From:
Sent: 02 August 2024 19:30
To: DCAdmin
Subject: Questions re: planning application: 2024/60/92031/E

Re: the application for residential development at Headlands Works, Headlands Road, Liversedge (ref: 2024/60/92031/E)

BOUNDARY TREATMENT DETAIL:
1800mm HIGH TIMBER VERTICAL BOARDED FENCING (1:50)

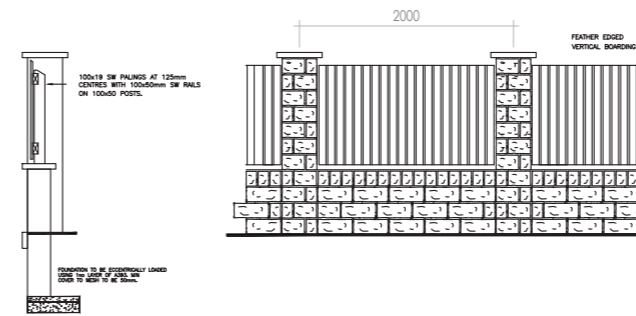
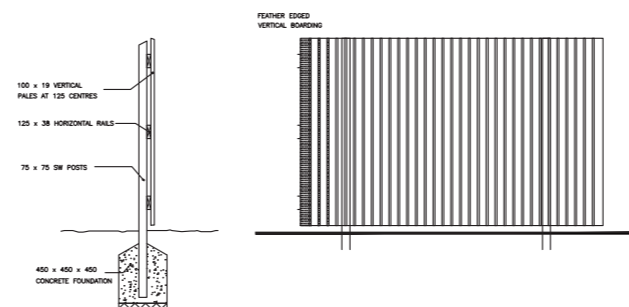
1. We would like to understand what form the boundary fence/wall will take between the development and our property. For example:
 - How high it will be
 - How close to our boundary fence it will be
 - How we will be able to gain access to the other side of our fence for maintenance etc?
2. Who will be responsible for maintaining the rectangle of land outlined in blue above, which appears to be fenced off as part of the proposal, and not part of the main site. It is currently very overgrown with ivy, nettles and other invading plants and we currently have to frequently enter that land to cut it back to prevent it from invading our property and
